October 27, 2022

**RE: Universe View Subdivision Traffic Impact Analysis Submittal
(Previously submitted as Volcano Cliffs Subdivision Lot 1, Block 8, Unit 17)
Huitt-Zollars Project No. R314494.01
COA DRB #PR-2020-004596
COA HYD #C09D016
COA DRC #709790, 709791, 709792, 709793**

We are requesting approval of the Traffic Impact Analysis (TIA) for Universe View Subdivision, which was previously submitted as Volcano Cliffs Subdivision Lot 1, Block 8, Unit 17. The TIA has been revised according to comments received from the City of Albuquerque on May 6, 2022. Below is a list of comments received, which are included in *italics* and our responses in **bold** text.

SITE PLAN

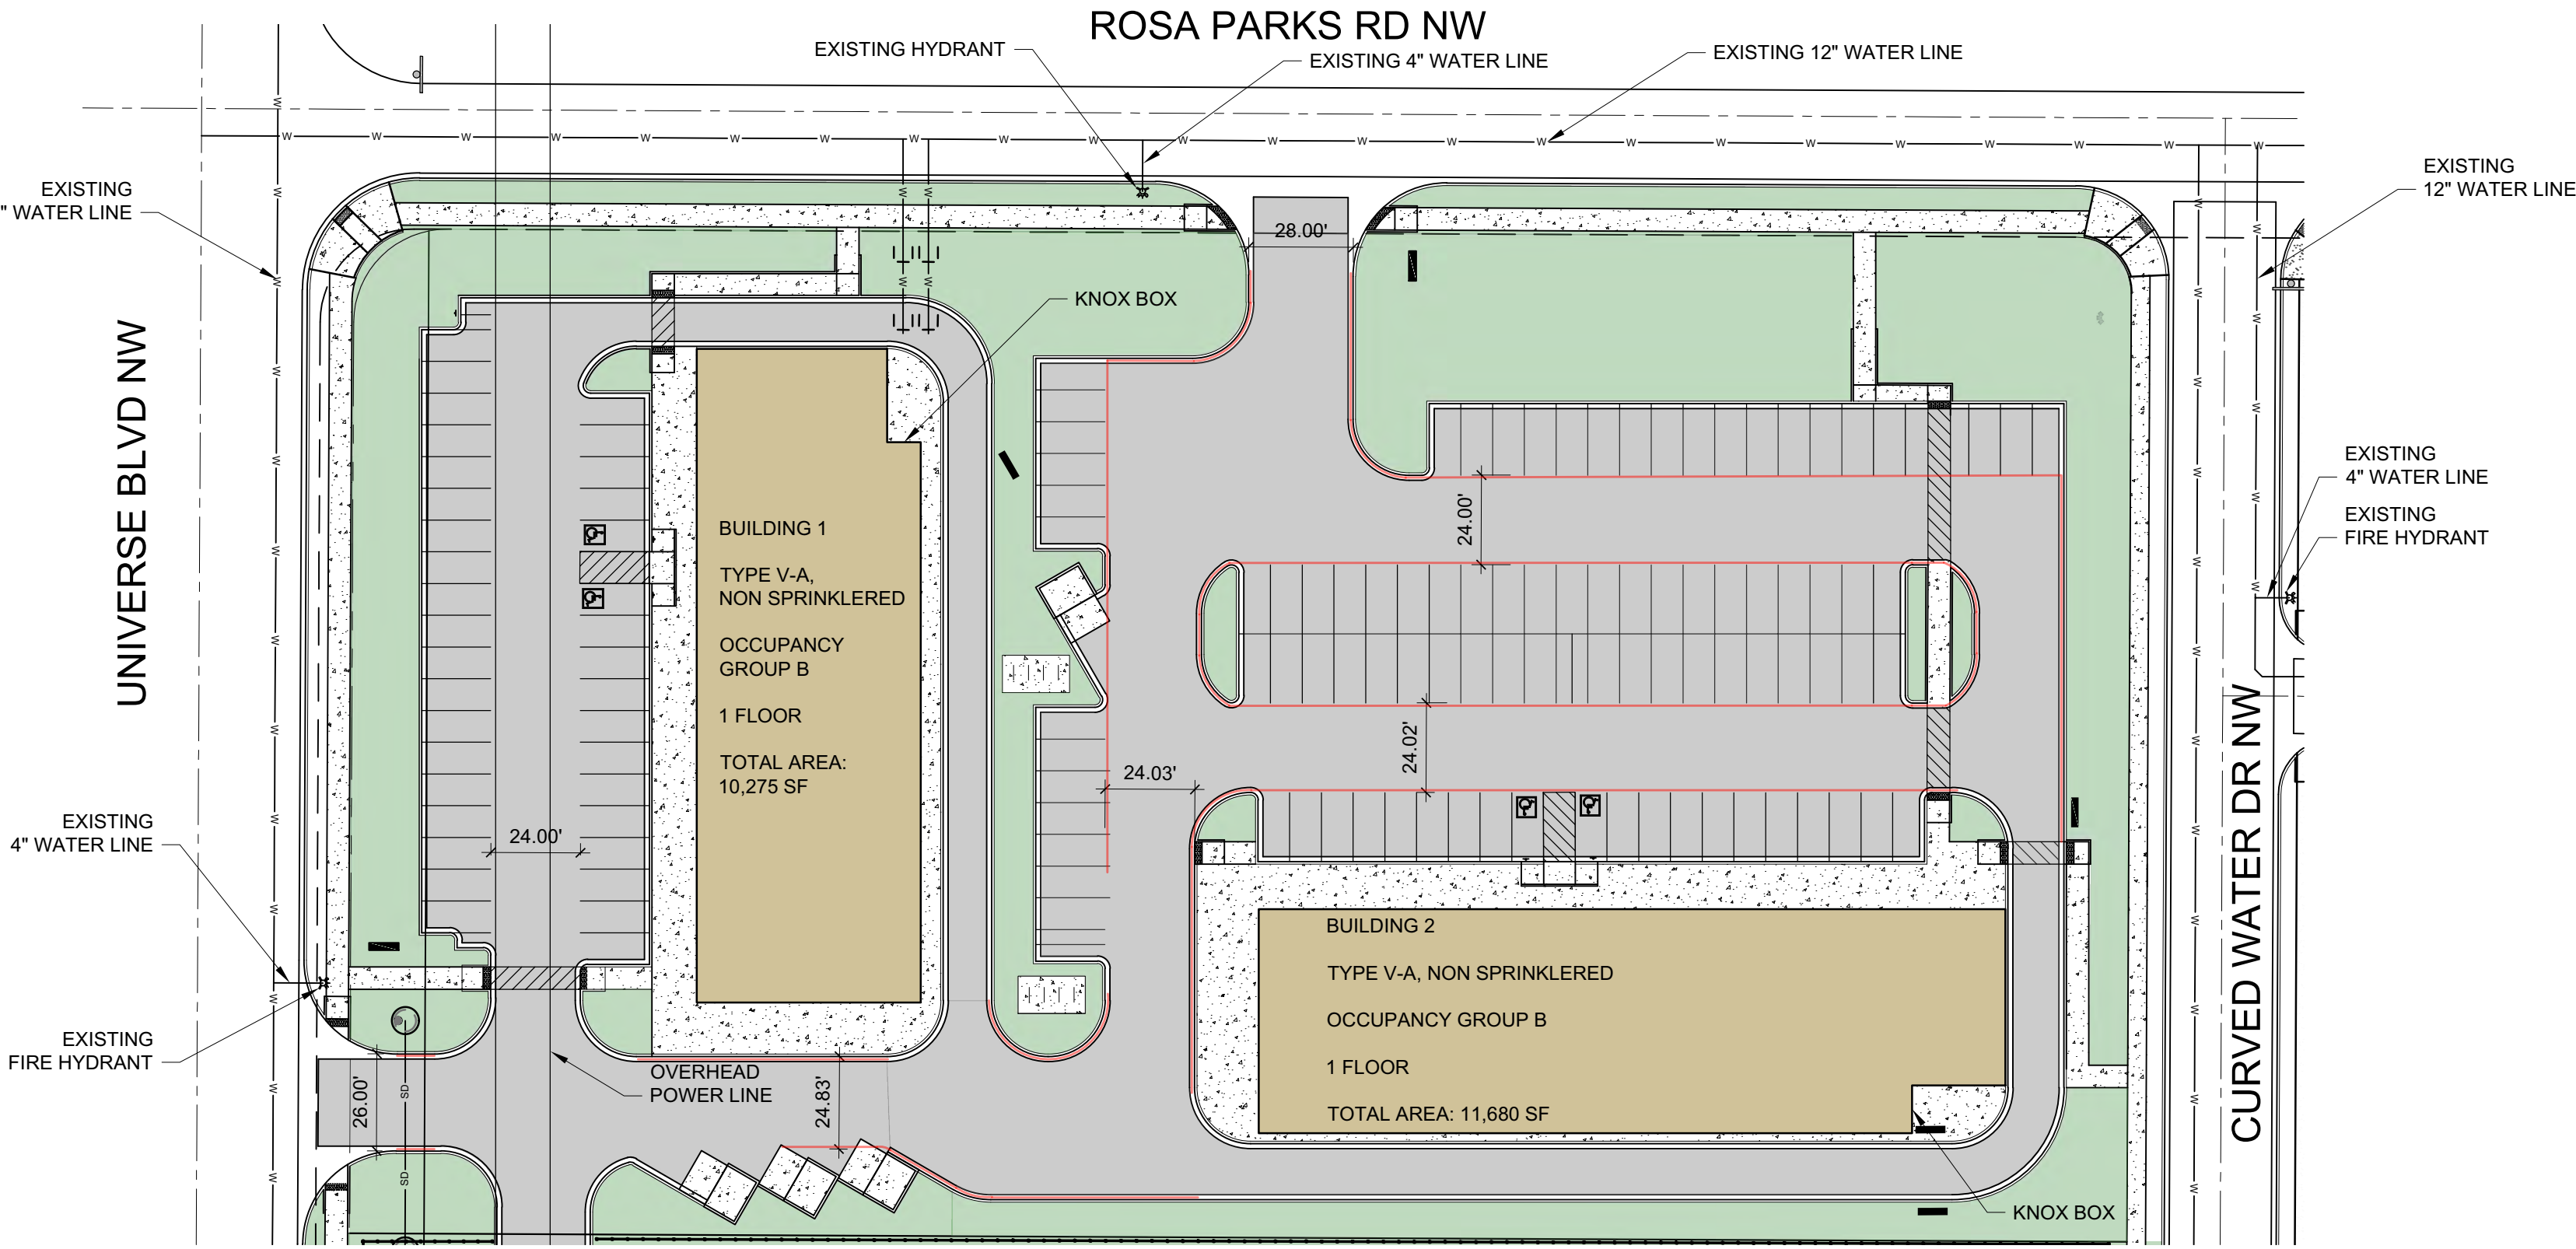
1. *Include a site plan in the introduction showing adjacent streets and approximate ROW.*
 - a. *Describe the existing and proposed street cross section, adjacent to the development, of Universe Blvd., Perezoso Dr. and Rosa Parks Rd. Include cross sections showing proposed lane widths and sidewalks. Universe and Rosa Parks have proposed bike lanes.*

A site plan and cross sections have been provided and existing and proposed cross sections have been described in the revised TIA.
2. *Universe Blvd./Paseo del Norte signalized intersection;*
 - a. *How should the Level of Service (LOS) be mitigated? Will the Paseo del Norte improvement project involve the Universe Blvd./Paseo del Norte intersection? If so, will that project address the LOS problems?*
